## MEMORANDUM

Subject: **Raising Cane's 4800 Montgomery Blvd. NE**  
Erosion and Sediment Control Plan  
*Engineer's Stamp Date 4/4/2022 (G17E011)*

The intent of this memo is to provide responses to Correction Notice #1 of the Project Raising Cane's 4800 Montgomery Blvd. NE, submitted to One Albuquerque Planning. Please find the corrections listed below with our response to corrections in **bold**.

C3.0

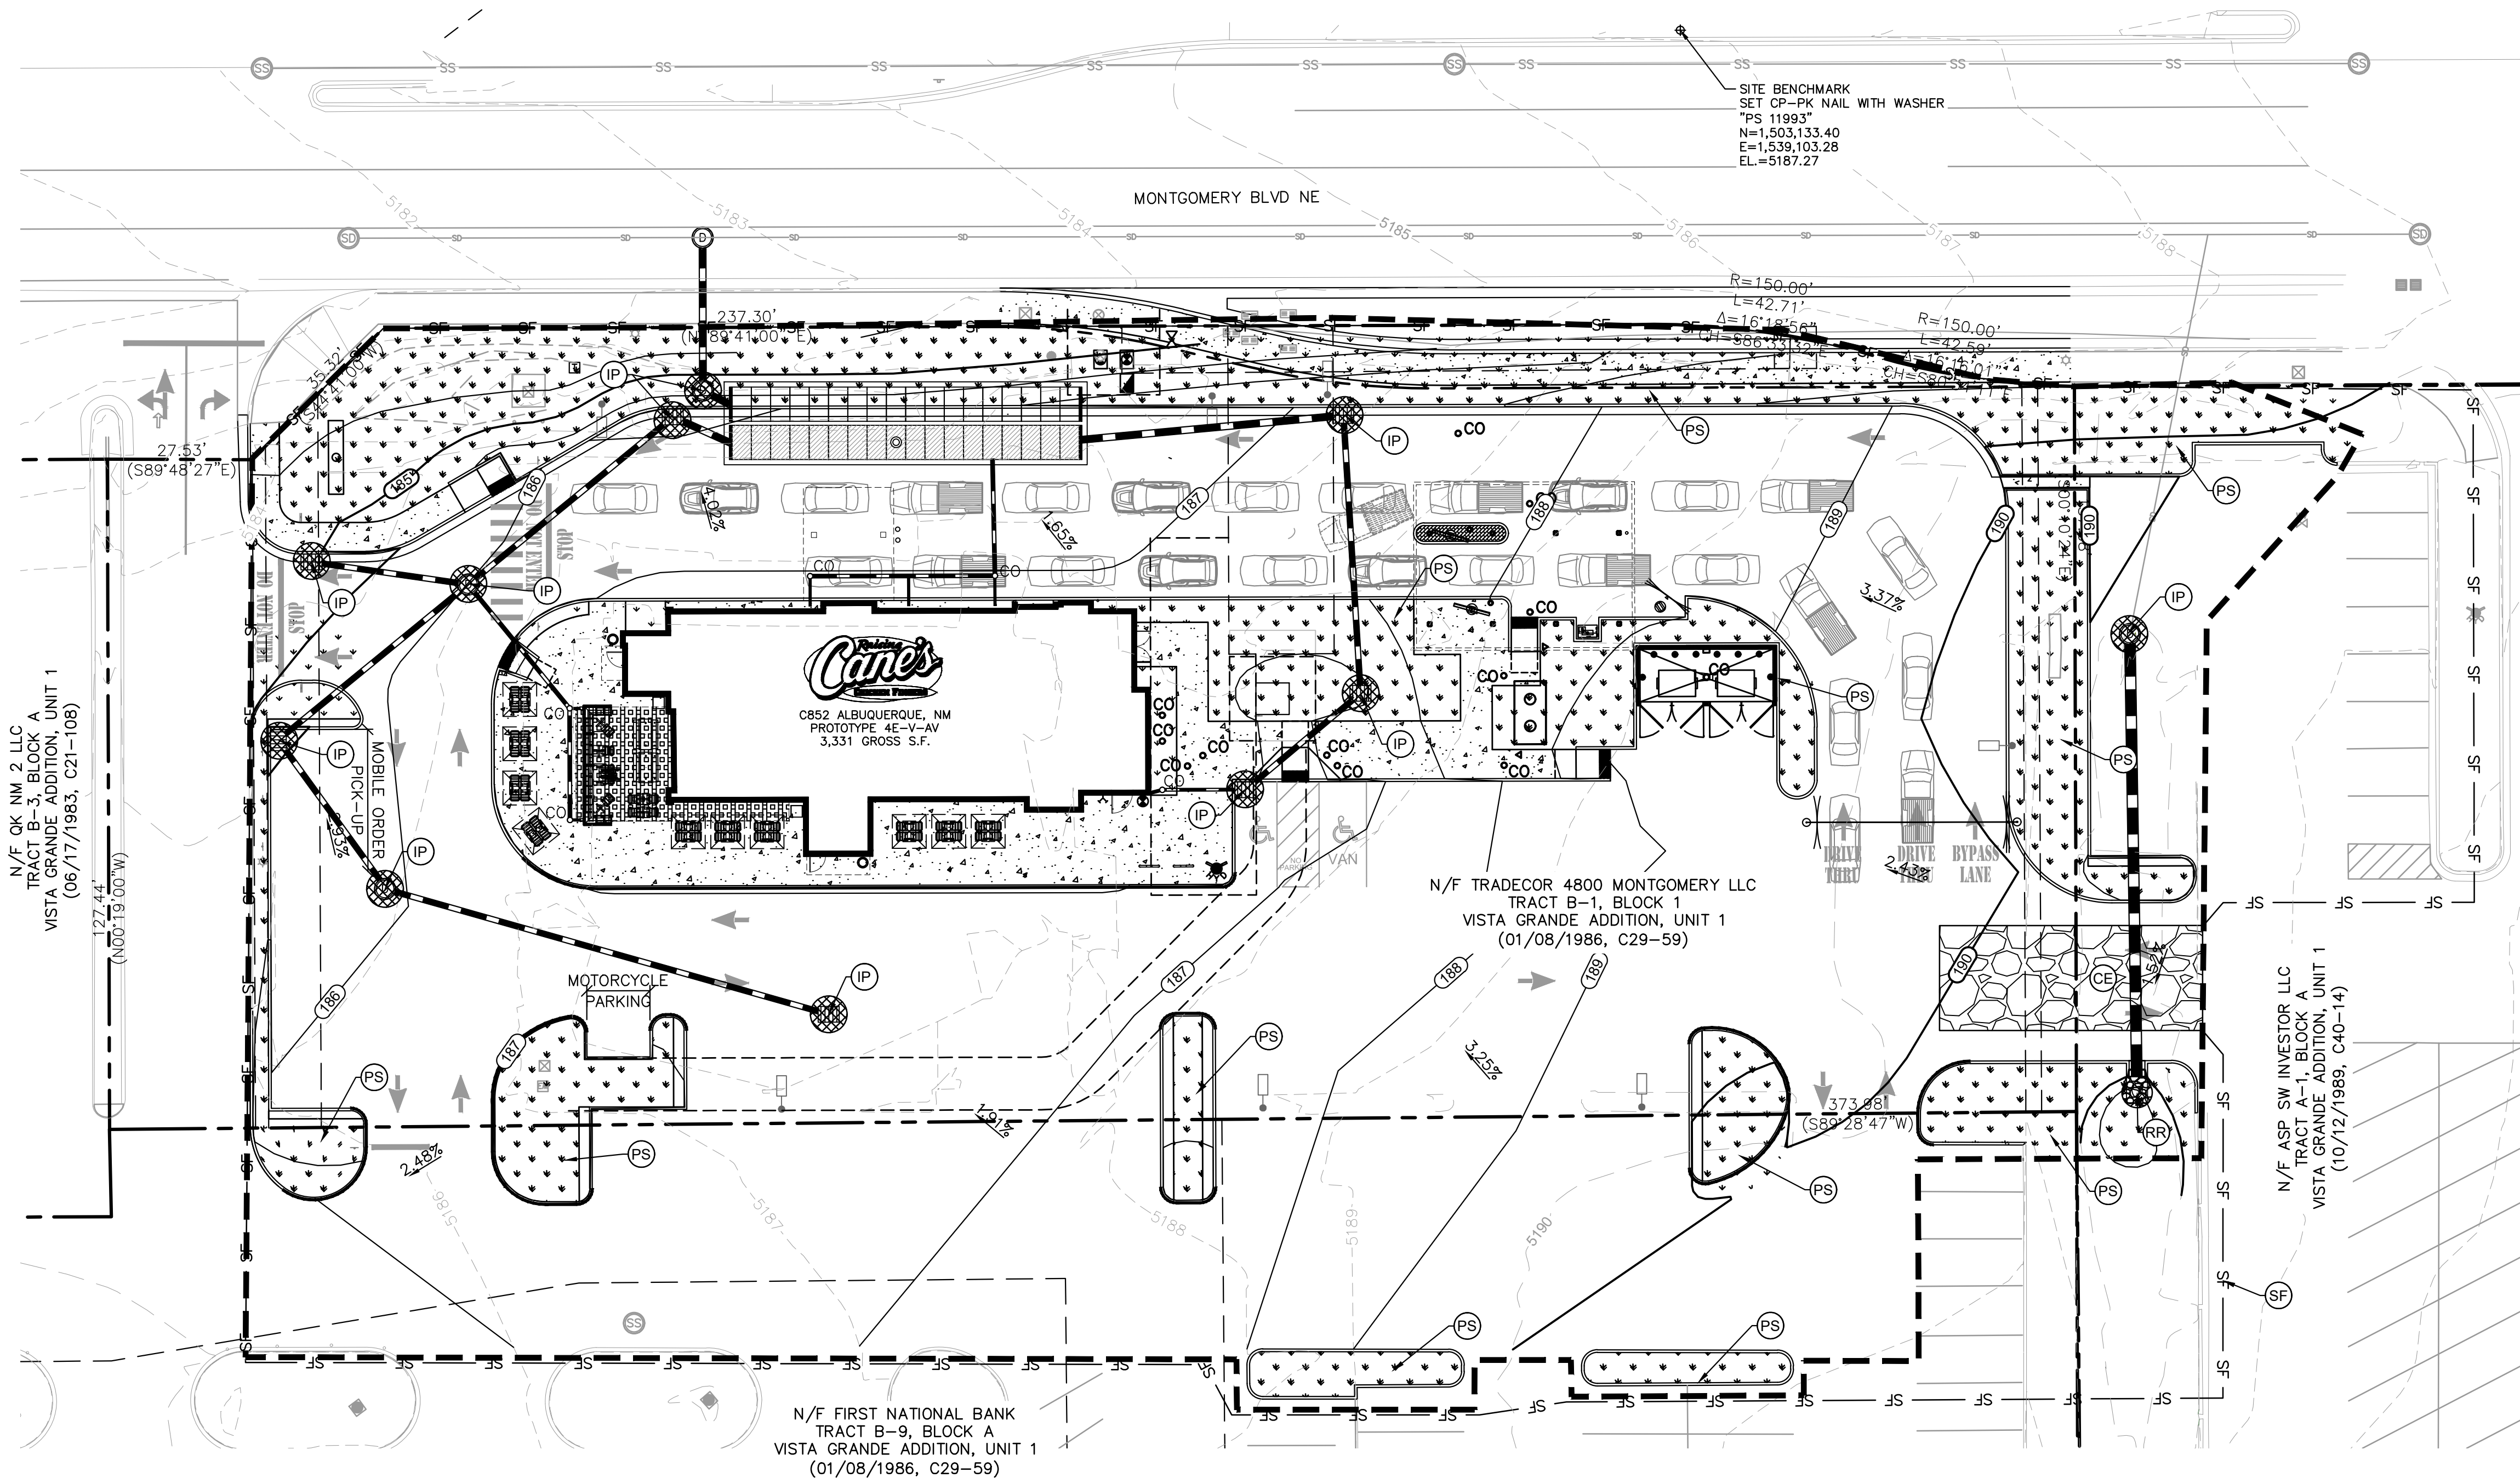
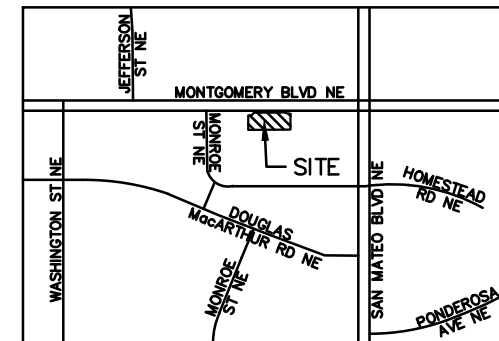
1. The ESC Plan can't be approved until after Hydrology approves the G&D Plan. The existing and proposed grades and storm drains must be shown on the ESC Plan and they must agree with the Grading Plan approved by Hydrology (CGP7.2.4.b.ii);

**Hydrology has approved the G&D plan, a copy of the approval has been included with this resubmittal.**

C3.1

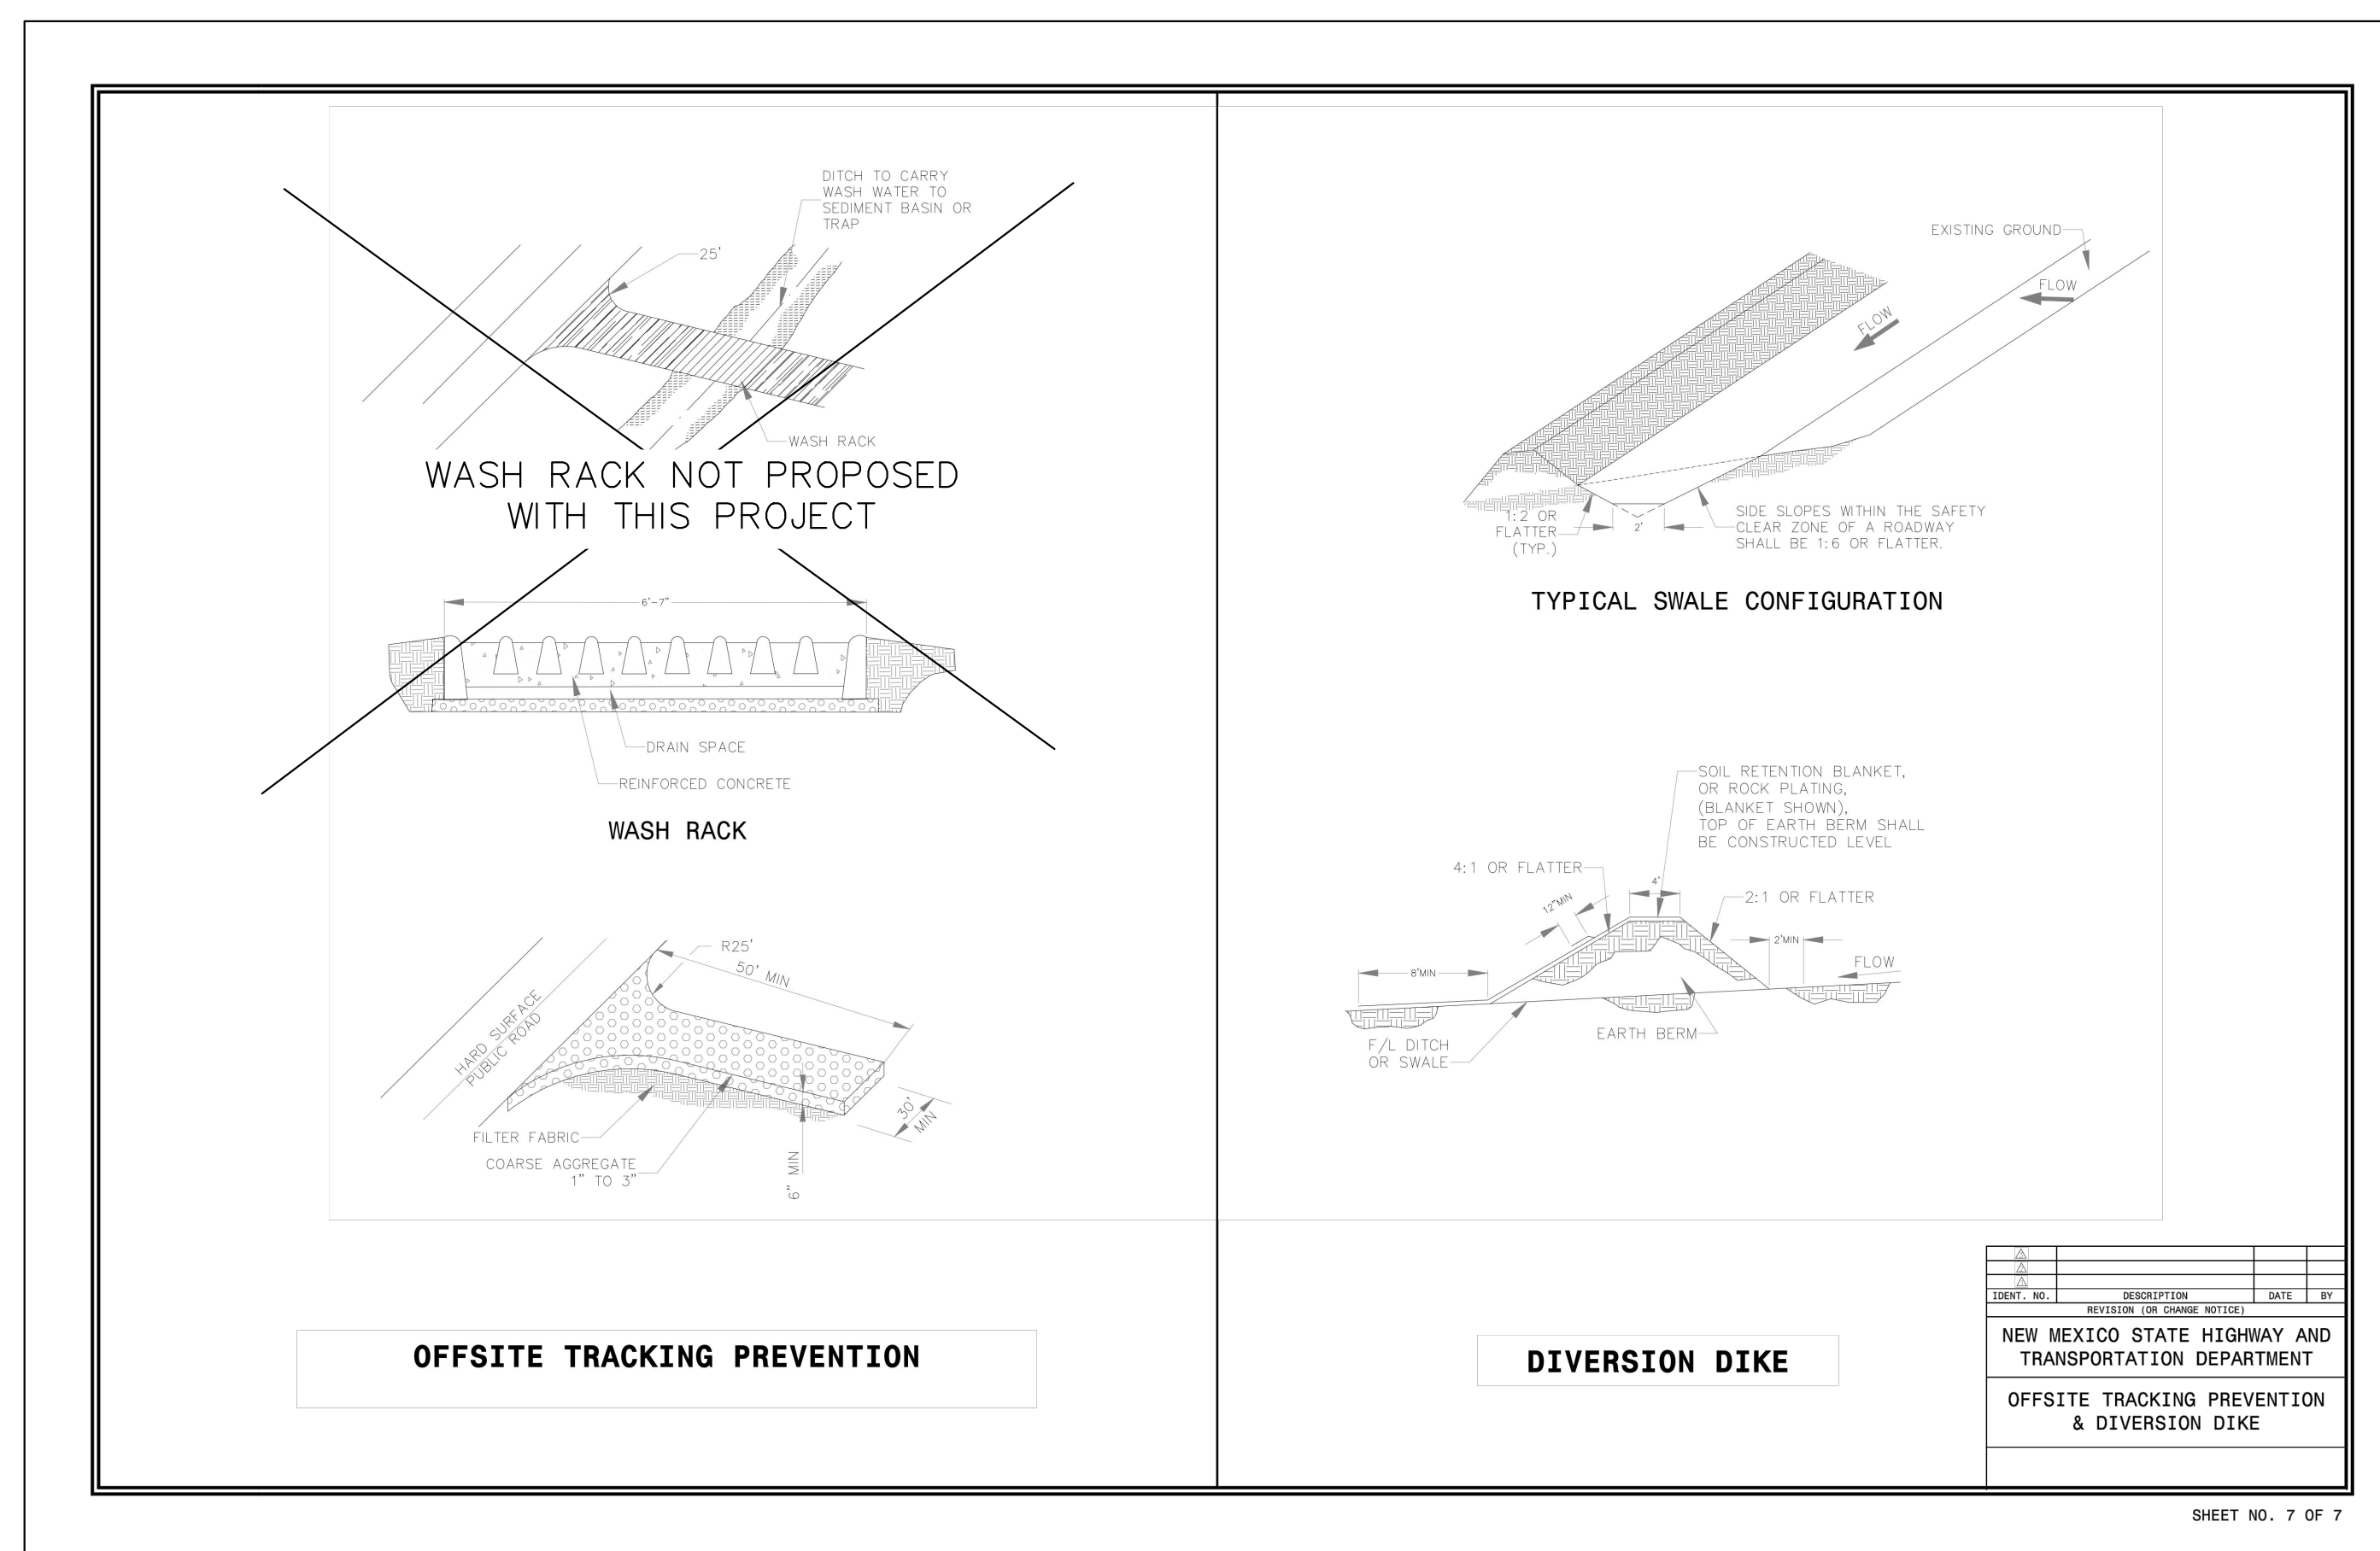
5. Update engineer's stamp date each time the plan is changed

**The Engineer's stamp date has been updated. See civil sheets for update.**
